# CITY OF PORTLAND

# BUILDING PERMIT

Located At 83 ALLISON AVE.

Job ID: 2011-05-1189-ALTR

1st Level Floor Plan and
 Accessory Unit Floor Plan

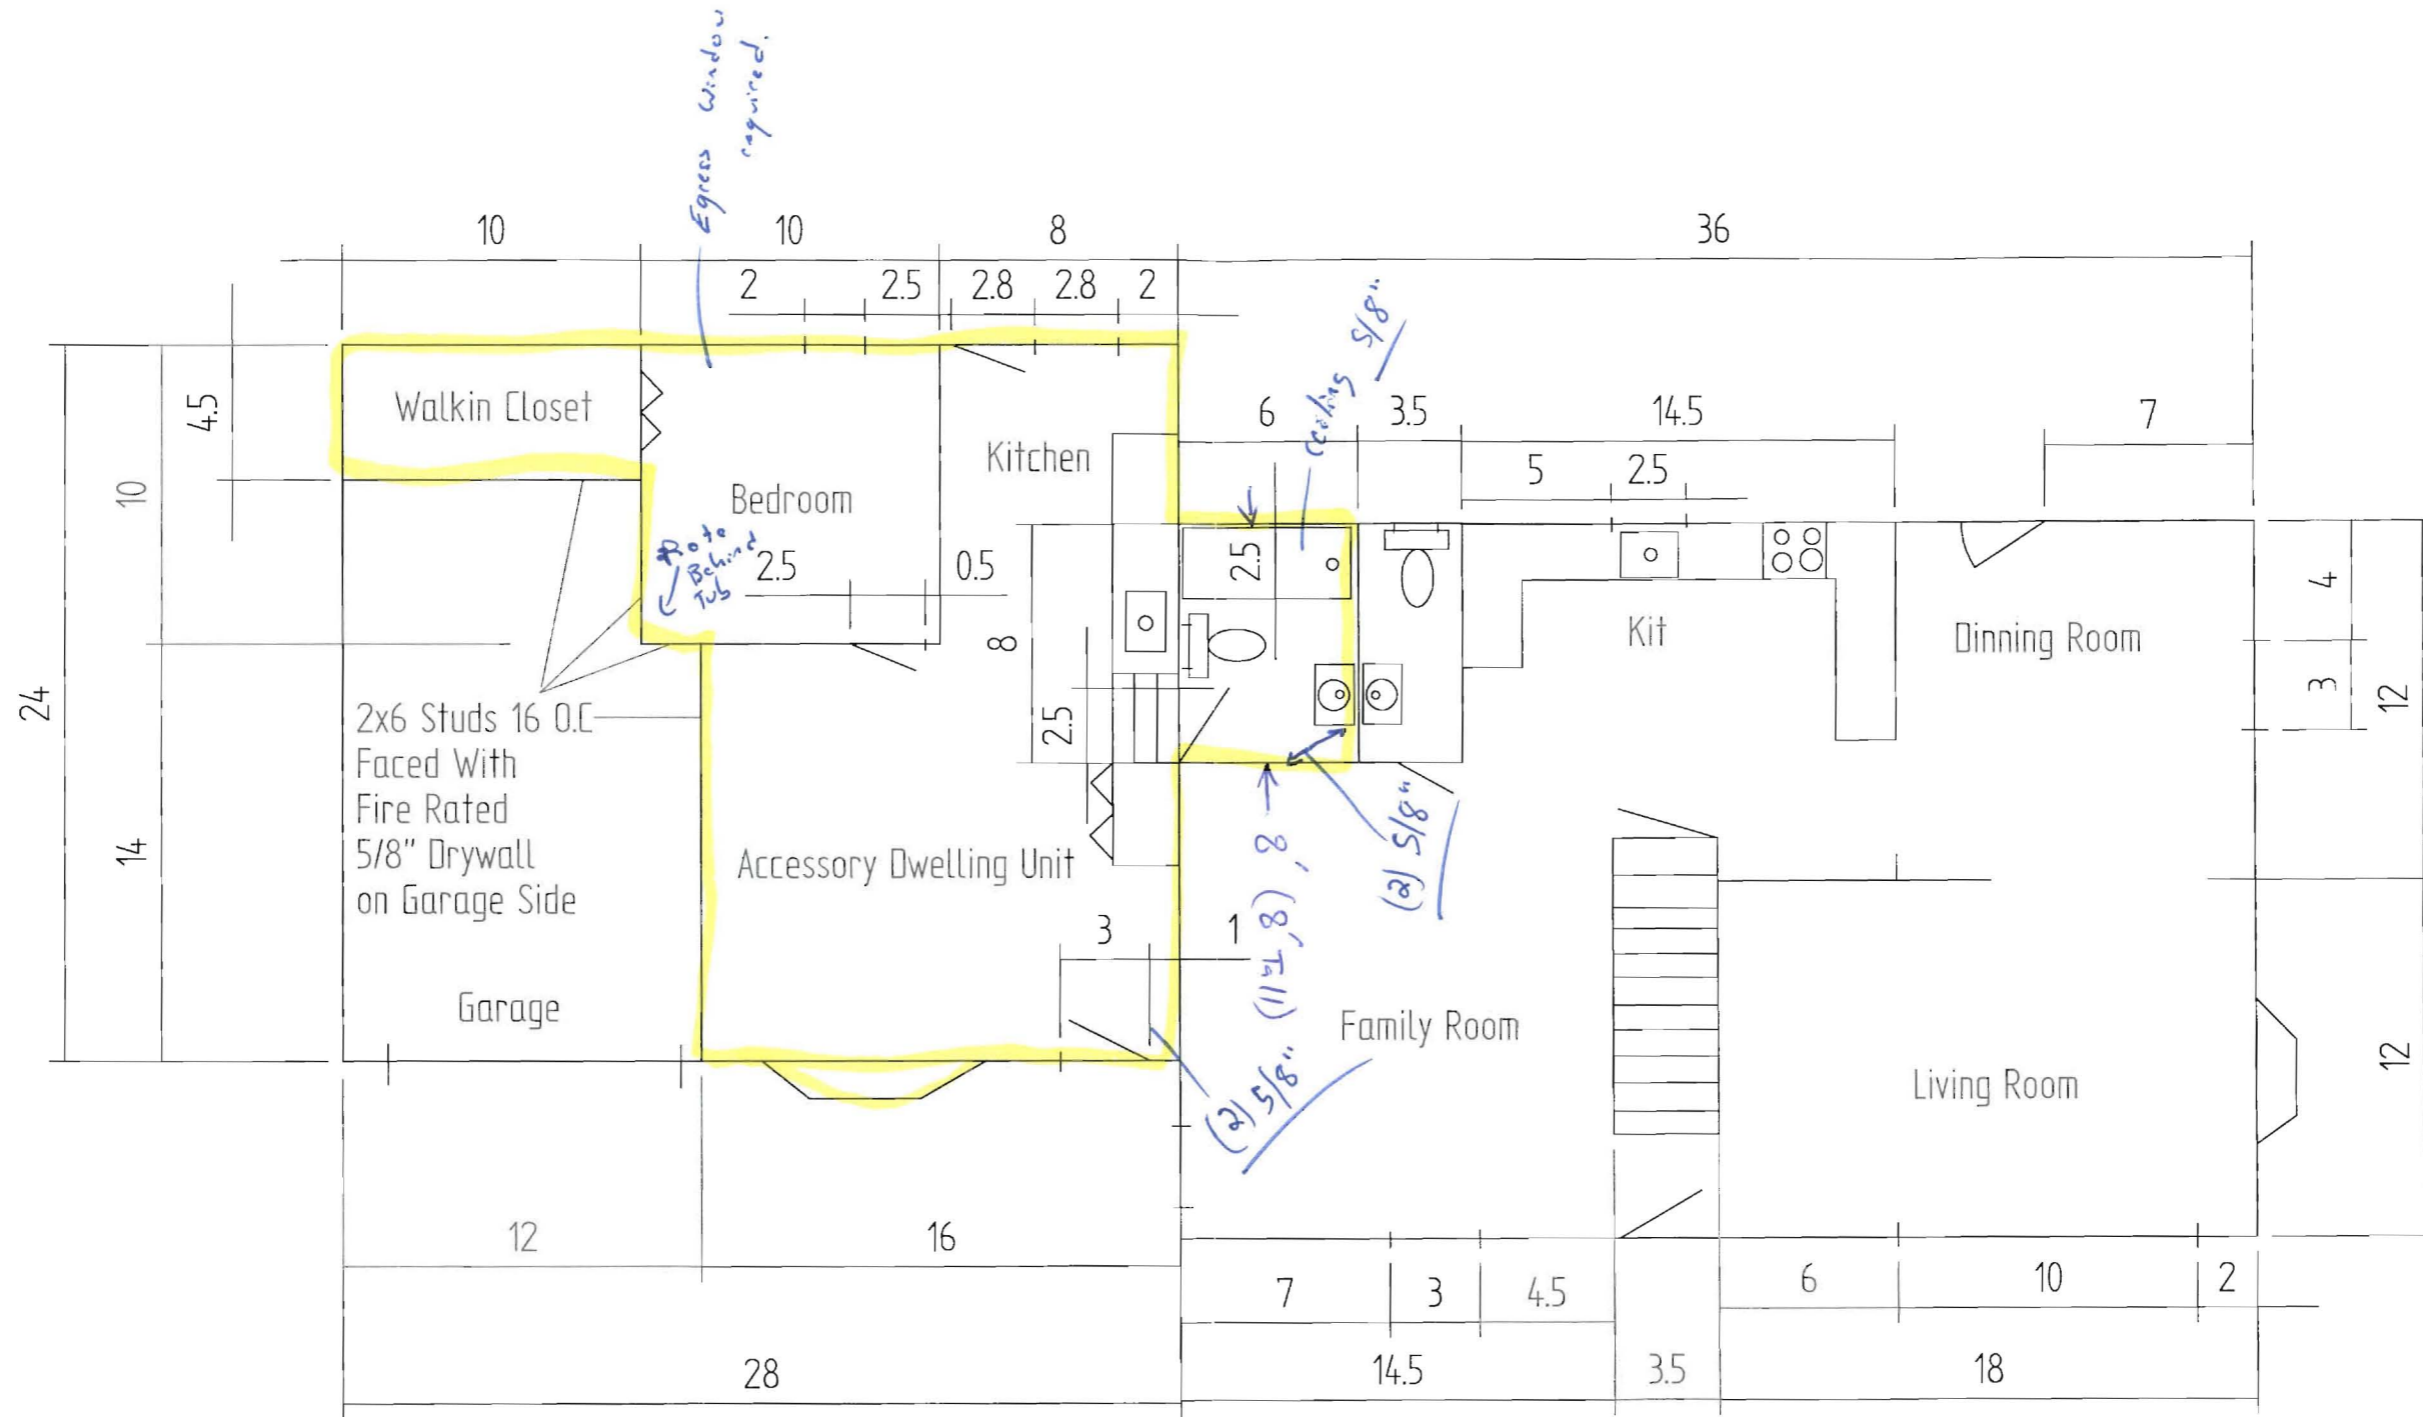
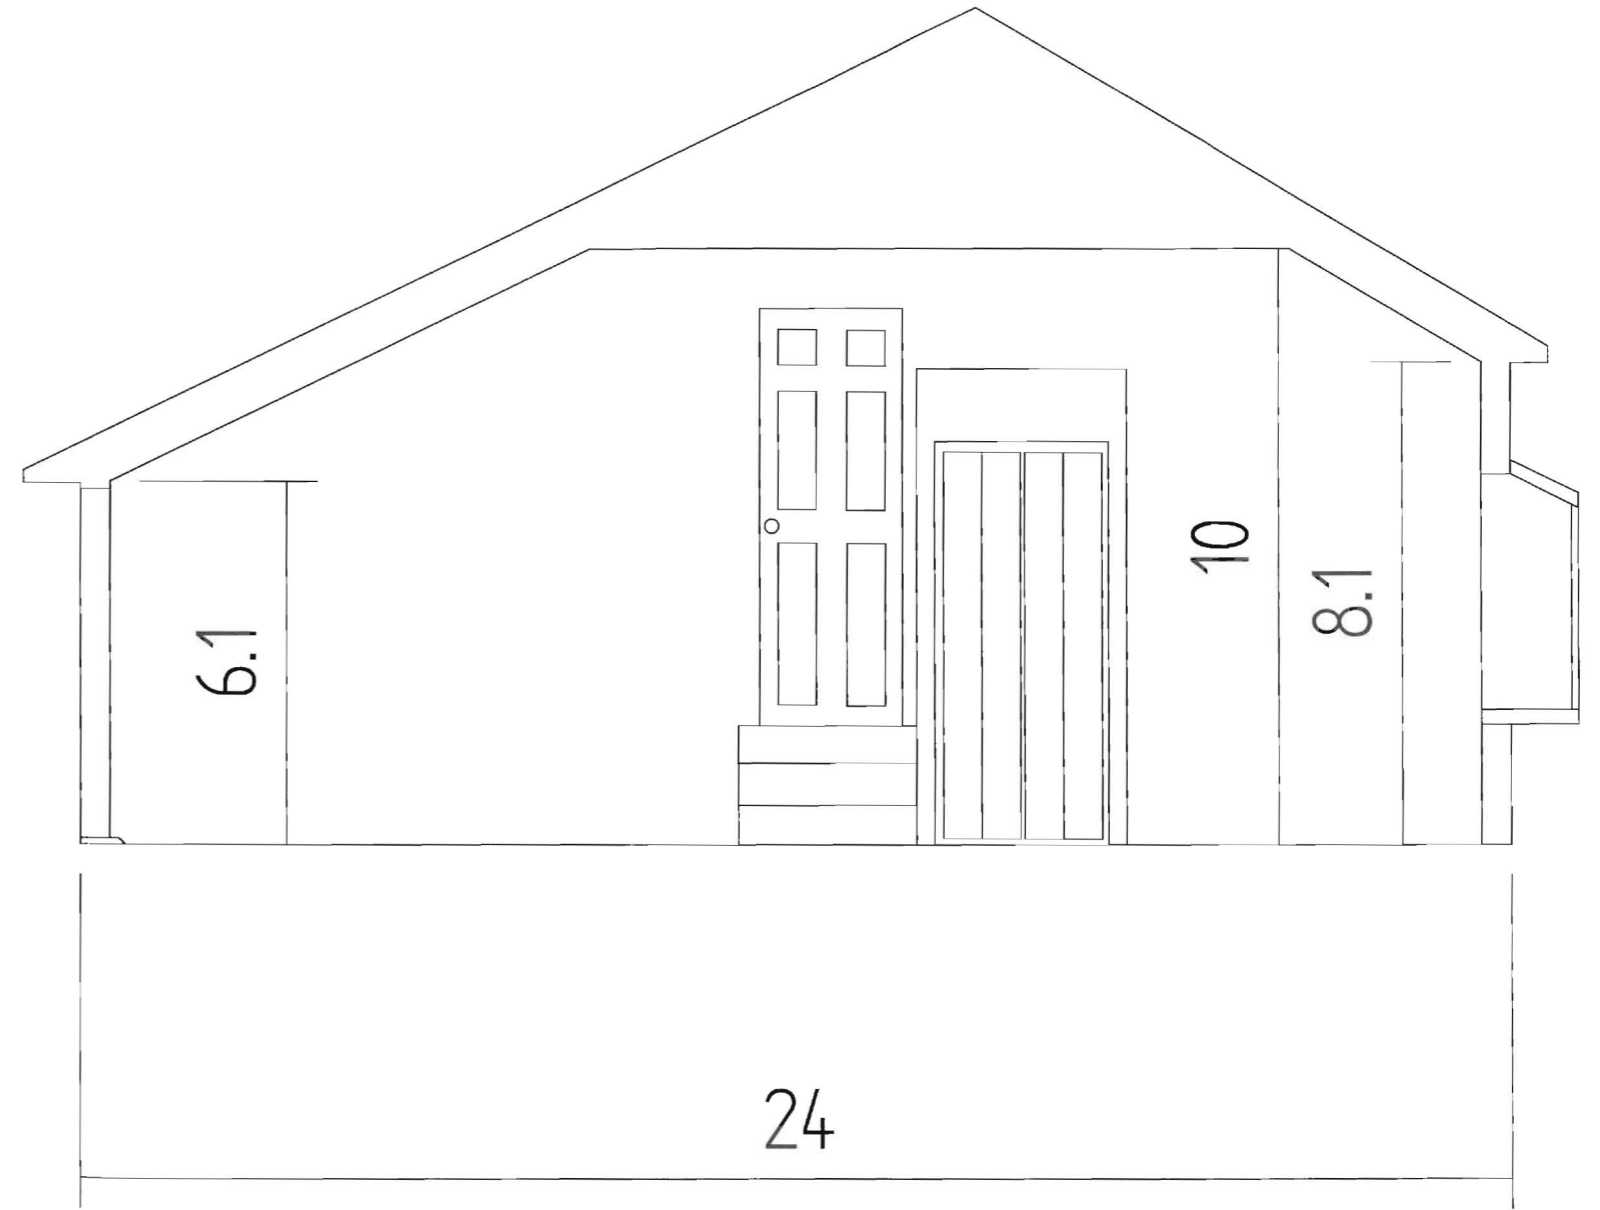
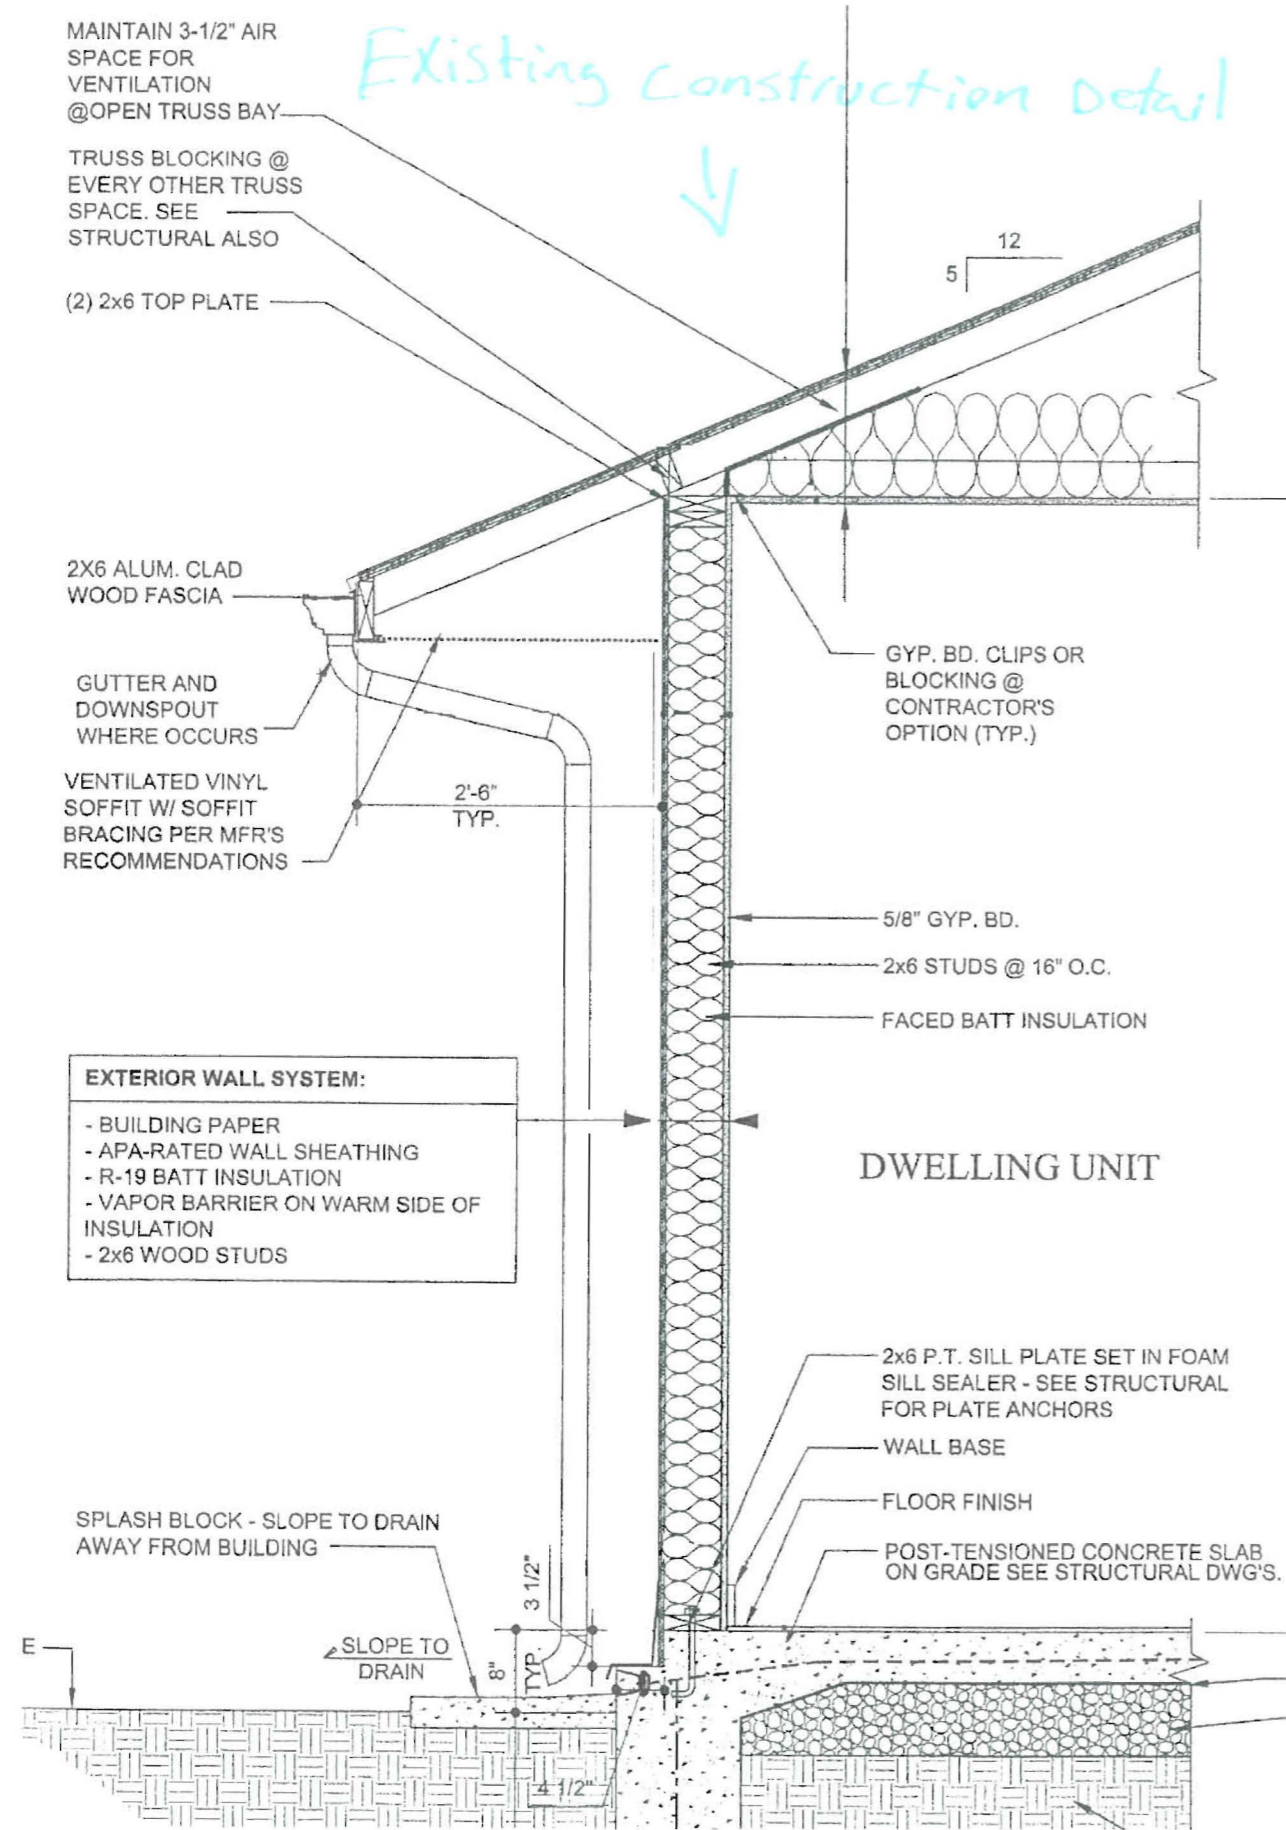
Need to fire rate between both units including walls, ceiling between house basement to new bathroom. Also need to rate back side of new walls in garage up to ridge. Exhaust Fans need to vented to the outside. Need a Egress window in new bedroom MA

- 06/09/11
- \* Interior wall separation units (2) 5/8" Gypsum
  - Garage to unit - 5/8" Gypsum
  - Egress window required/or Escape
  - SA/CO Det. required JCA

1. The dwelling units (and supporting construction) shall be separated from each other by wall and/or floor assemblies having not less than a 1-hour fire-resistance rating when tested in accordance with ASTM E 119 or UL 263. Fire-resistance-rated floor-ceiling and wall assemblies shall extend to and be tight against the *exterior wall*, and wall assemblies shall extend from the foundation to the underside of the roof sheathing. Note: Through penetration require equal separation from each dwelling unit.

3. Mechanical or natural ventilation required in the bathroom.
4. A photoelectric Carbon Monoxide (CO) detector shall be installed in each area within or giving access to bedrooms. That detection must be powered by the electrical service (plug-in or hardwired) in the building and battery.

6. **A code compliant emergency escape shall be provided in the bedroom.** Window sills in locations more than 72 inches from finished grade shall be a minimum of 24 inches (no higher than 44 inches) above the finished floor of the room.
